Our Ref: 19139

18 February 2021

**RE: 90-102 REGENT ST, REDFERN WEEHURREGENT PROPOSED STUDENT ACCOMMODATION
RESPONSE TO SUBMISSIONS
LOADING DOCK AND CONSTRUCTION TRAFFIC MANAGEMENT**

DWG No.		19139CAD011	
		FIGURE 2	
DATE STAMP			
18 FEBRUARY 2021			
PROJECT No.		SCALE	REV.
19139		1:75 @A3	A

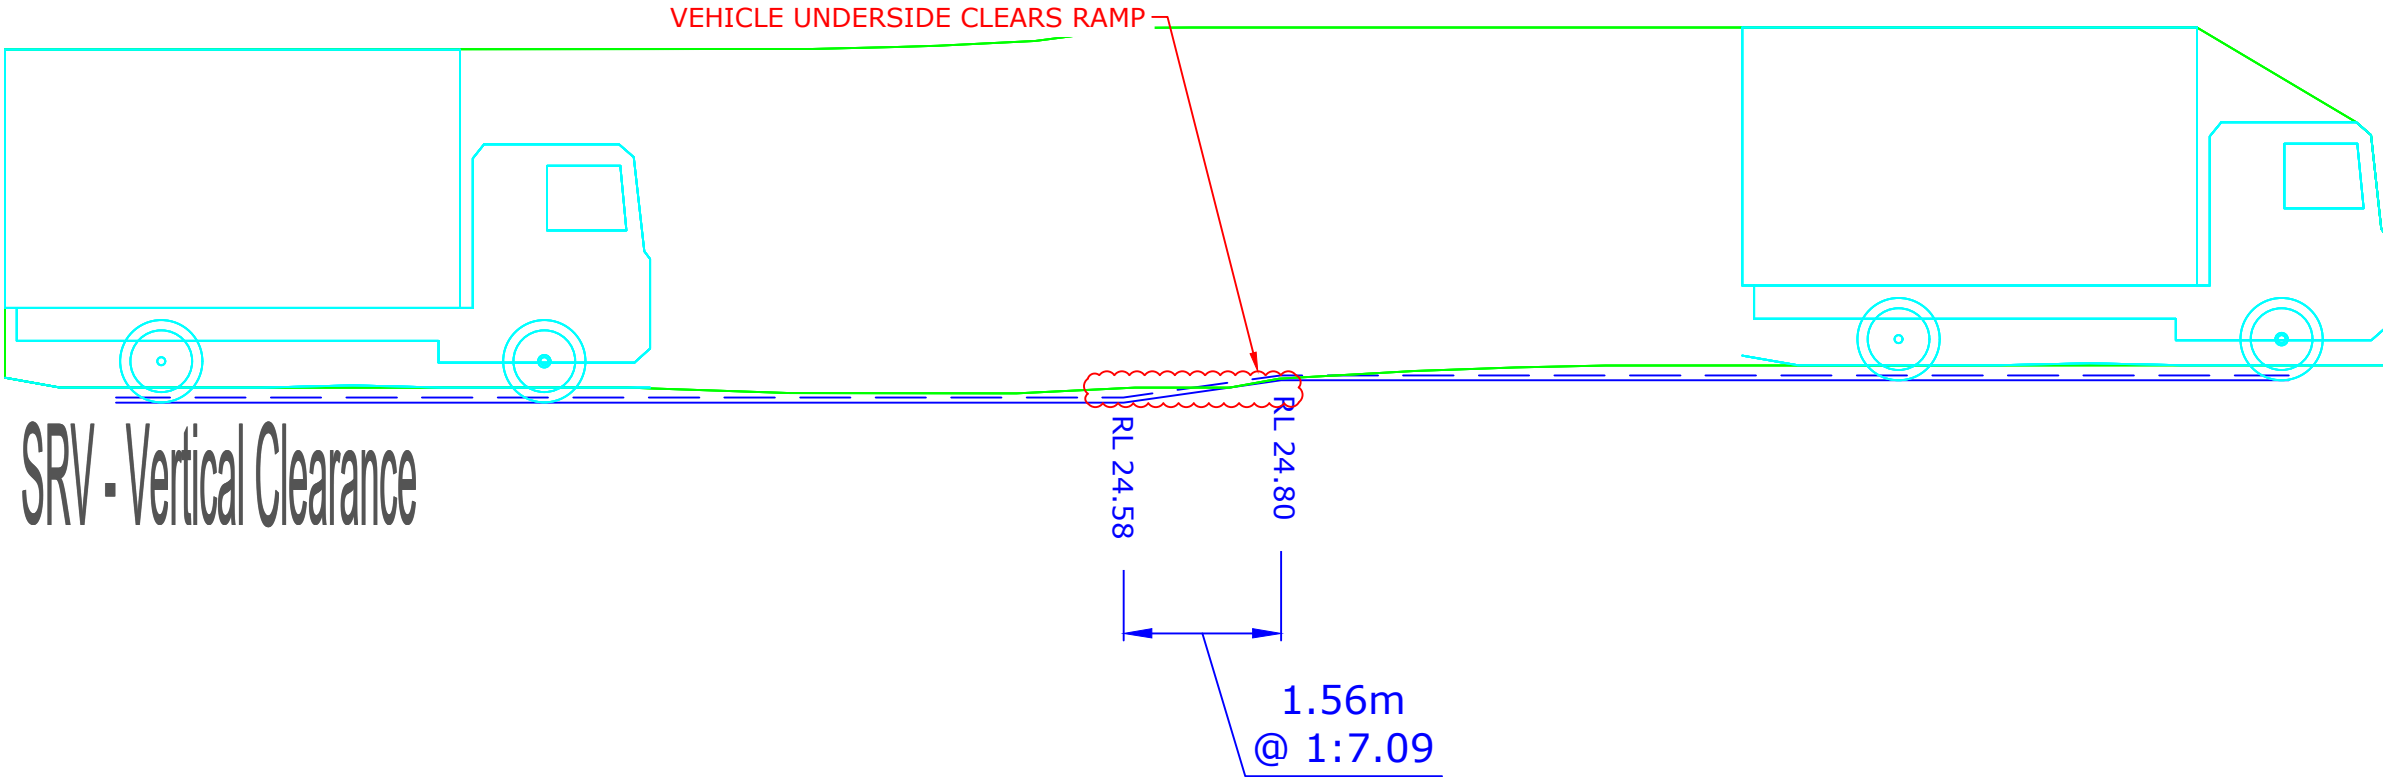
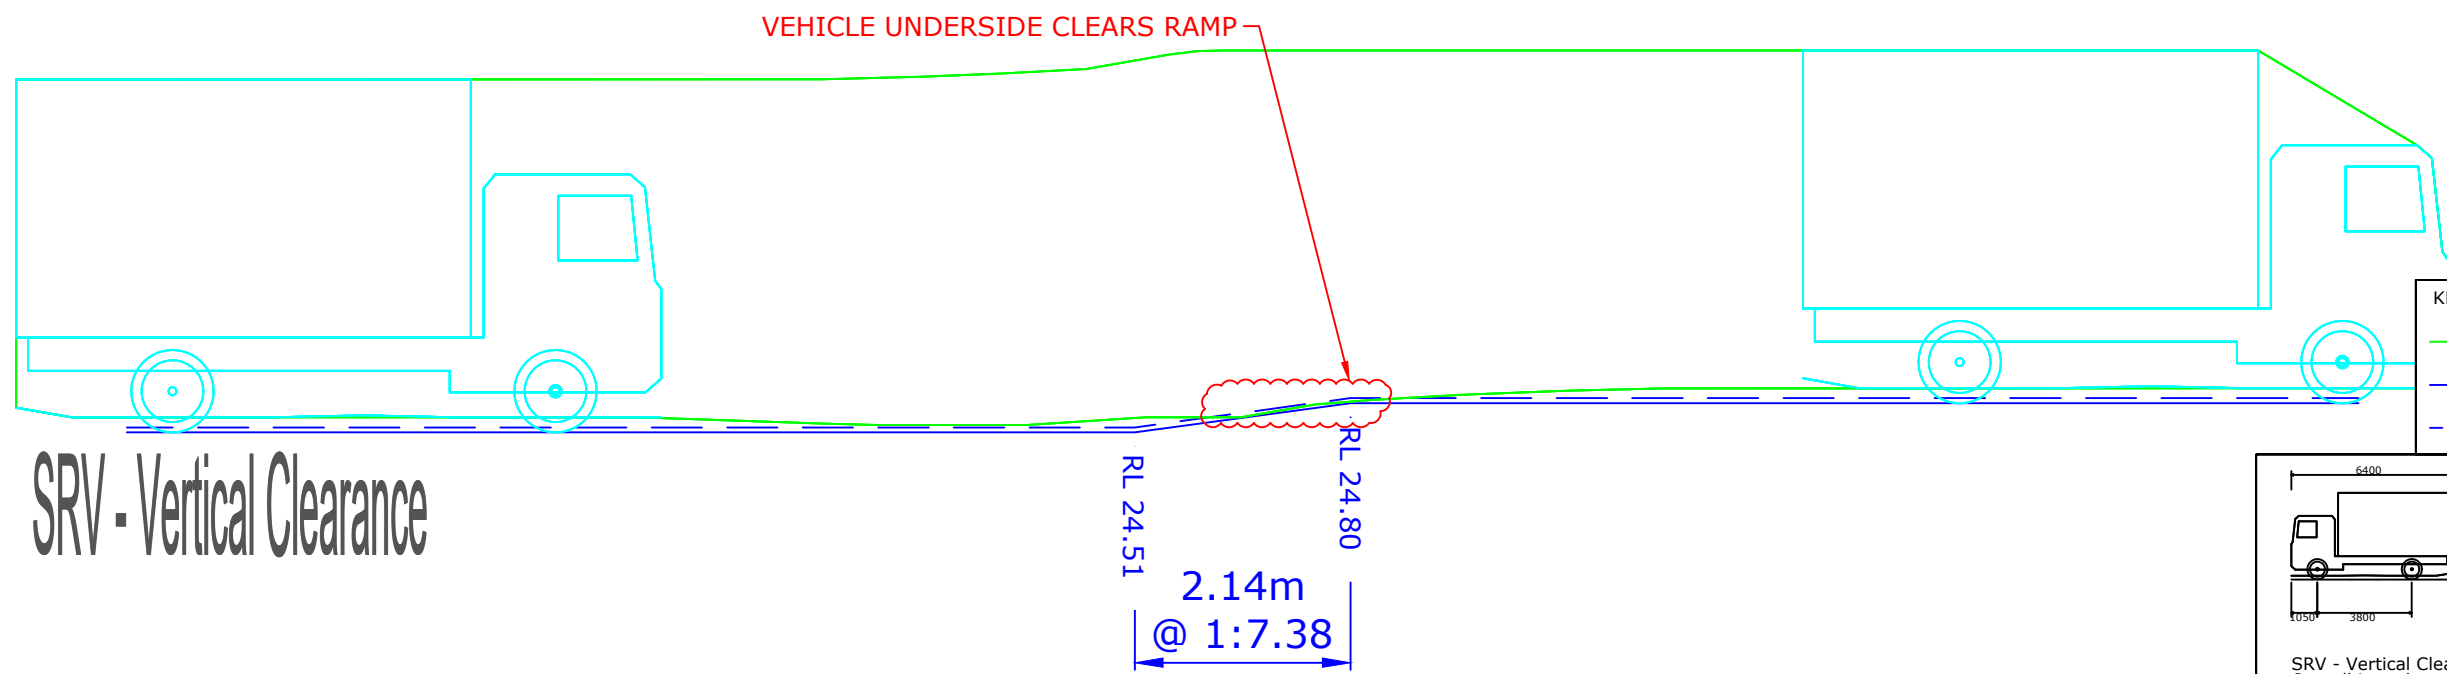
Issue: The architectural plans do not clearly illustrate the access and loading arrangements of the development. It is indicated that loading will be provided in the basement. However, a ramp access to the turntable is not shown. Additionally, the proposed driveway must be in accordance with the requirements of Sydney DCP 2012 and the relevant Australian Standard.

The level of the loading dock and associated vehicle turn table will sit at RL 24.800 which is slightly higher than the pavement levels at the site's frontage to William Lane which are RL 24.467 and RL 24.661. A short transition ramp is provided to accommodate the grade changes to from the road and footpath to the loading dock.

The grade and specifically the vehicle approach pathways will accommodate vehicle access to and from the loading dock as required by AS2890.2.

It is noted in accordance with AS2890.2 a vehicle ground clearance test has been undertaken along the proposed entry and exit wheel paths for a SRV accessing the turntable. The ground clearance test (see Attachment A) demonstrated that the under side of a SRV as defined by AS2890.2 would not scrape on the proposed access driveway.
